From: Justin Daigneault <justind@opechee.com>
To: "buildinginspections@portlandmaine.gov" <buildinginspections@portlandmai...>
CC: Chris Pirone <cpp@portlandmaine.gov>, Nick Cricenti <ncricenti@sfceng.com>
Date: 6/24/2013 10:11 AM
Subject: 311-331 Commercial St- Marriott Mixed-Use- 3rd Party Chapter 10 Analysis Plan Corrections
Attachments: A02 Second Floor Plan MarriottCourtyard Portland ME 06-17-13.pdf; A0.1 Code Info Marriott Courtyard Portland ME 06-24-13.pdf; SFC Engineering Revised Chapter 10 Analysis 06-13-13.pdf; FW: Courtyard Portland Elevator Lobby Doors, etc; A0.3 Code Plans Marriott Courtyard Portland ME 06-18-13.pdf; A0.2 Code Plans Marriott Courtyard Portland ME 06-18-13.pdf

Please find the attached third party review of our projects chapter 10 compliance. Each item numbered below corresponds to the general comments number on the attached review sheet. The items were taken care of as follows.

A0.1

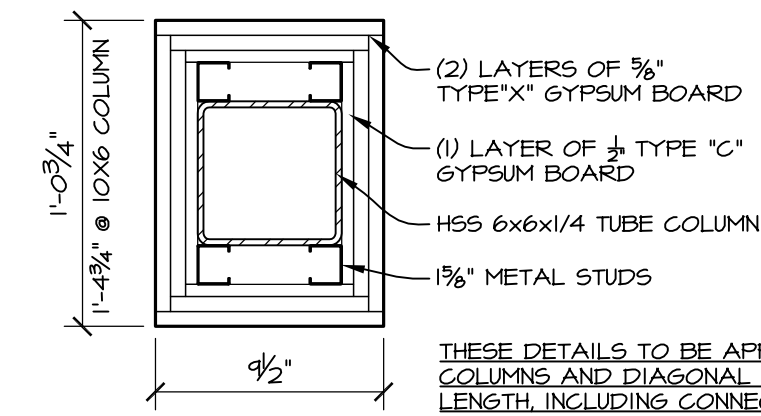
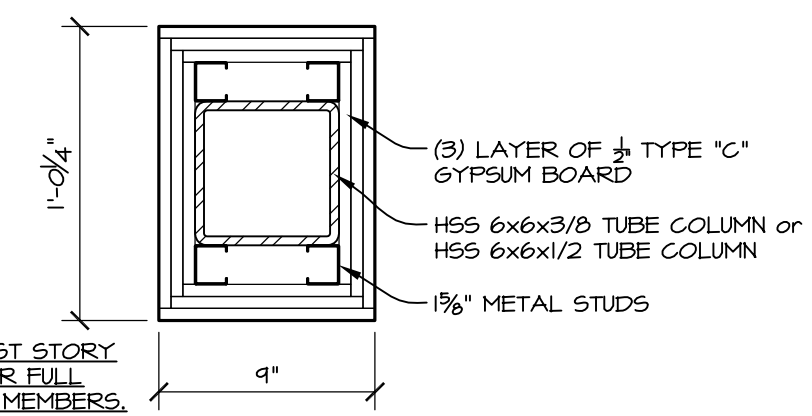
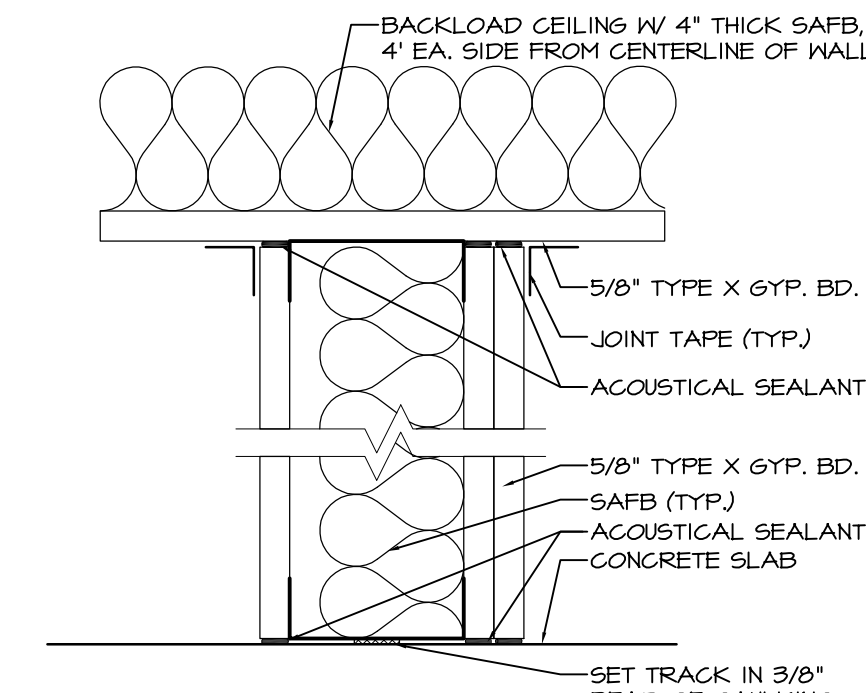
1. City of Portland: Code of Ordinances is now referenced on the attached A0.1 sheet
2. and 3. The meeting room dead end distance in excess of 20' was addressed as shown on the attached A02 plan. In doing so, we have added a door at the left most stairwell on the 2nd floor so that we now meet the requirements. This item is also addressed in the email thread shown attached. The requirement does not have to be met at the above floor levels as they are separated horizontally as required.
4. See general note on A0.2 and A0.3 sheet- all guestrooms entries will have a 20 minute rating, resist the entrance of smoke, and have a self closing device as required.
5. See general note on A0.1 sheet- all emergency lighting tied into generator as required
